CITY OF ALBUQUERQUE

February 13, 2020

RE: **7901 Las Lomas NE**
Revised Grading Plan Stamp Date: 2/10/20
Drainage File: D16D002I

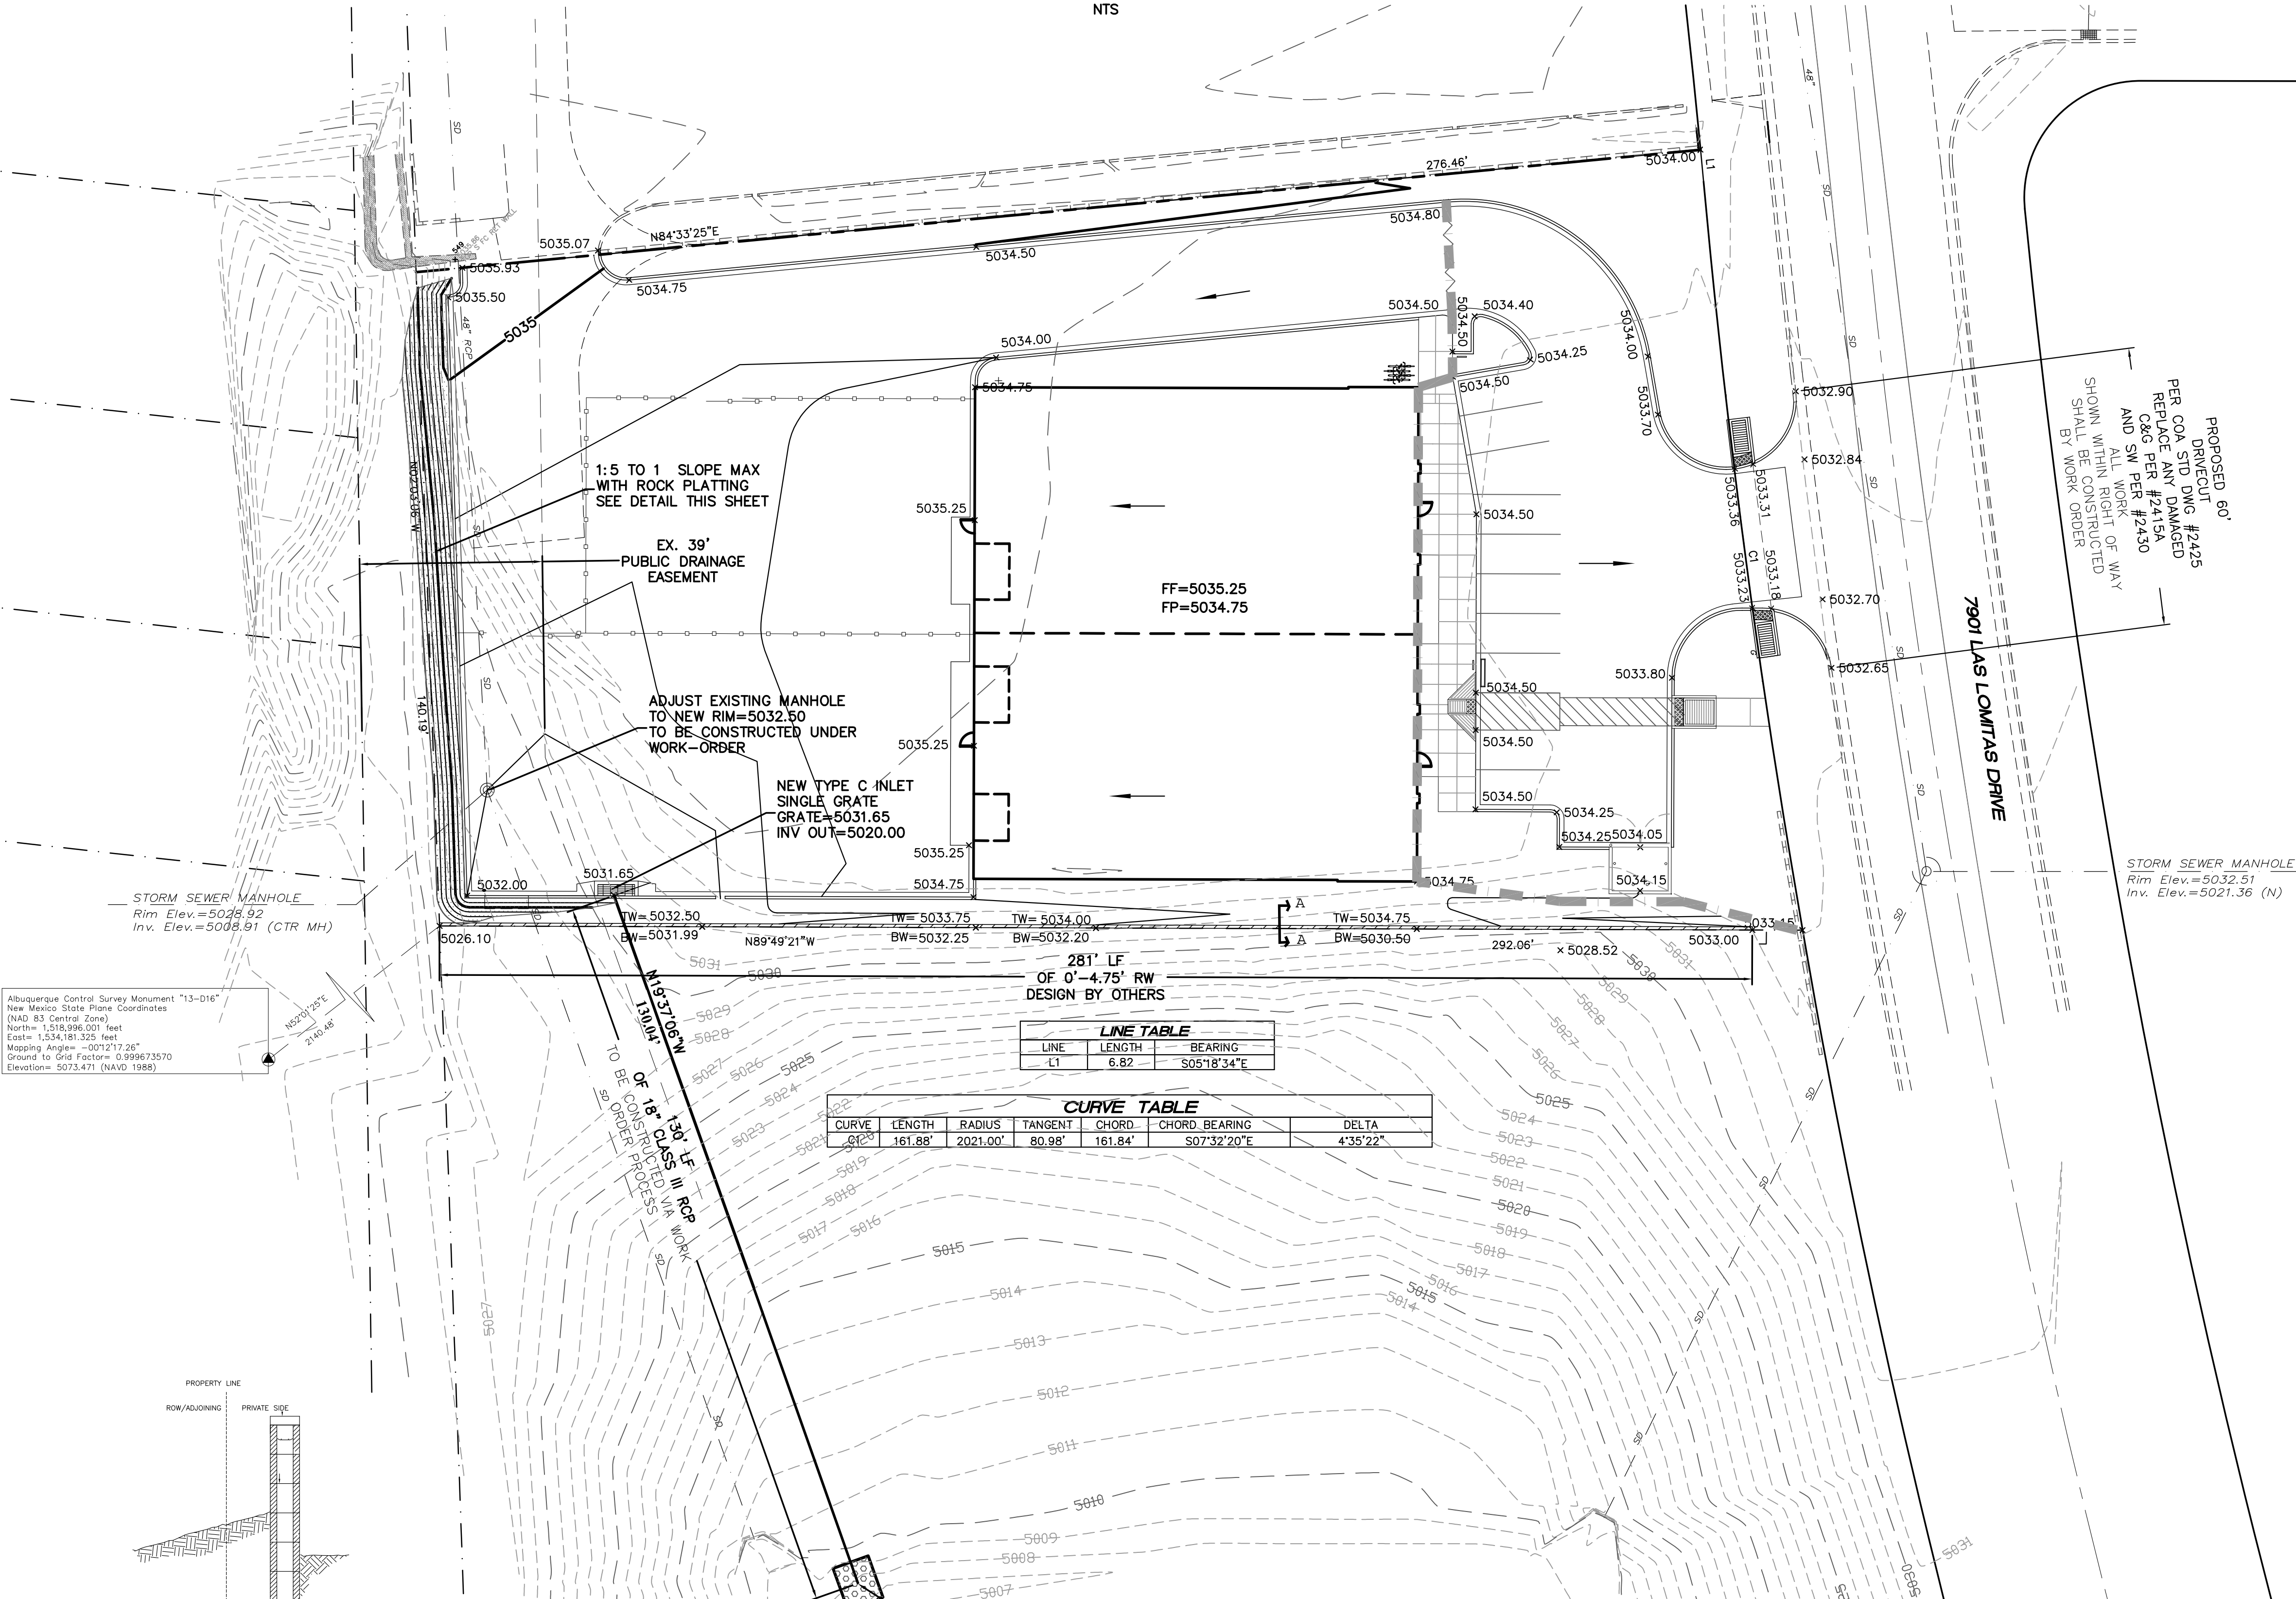
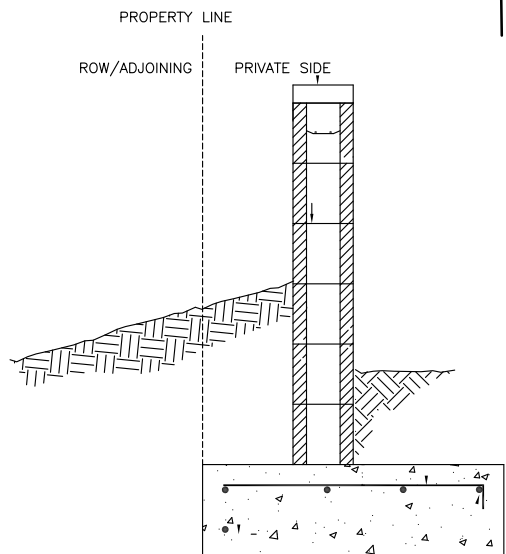
1. Extend the storm drain to outfall at the bottom of the pond. Alternatively, you could provide a concrete swale to convey the drainage from the pipe outlet to the bottom of the pond (will require channel capacity calculations). For either option the rip-rap pad will be needed at the pond bottom.

2. Provide a section through the proposed retaining wall; ensure it is wholly contained on the private property. How will the existing fence be affected by this wall? Will it need to be rebuilt on top of, or adjacent to, the retaining wall?
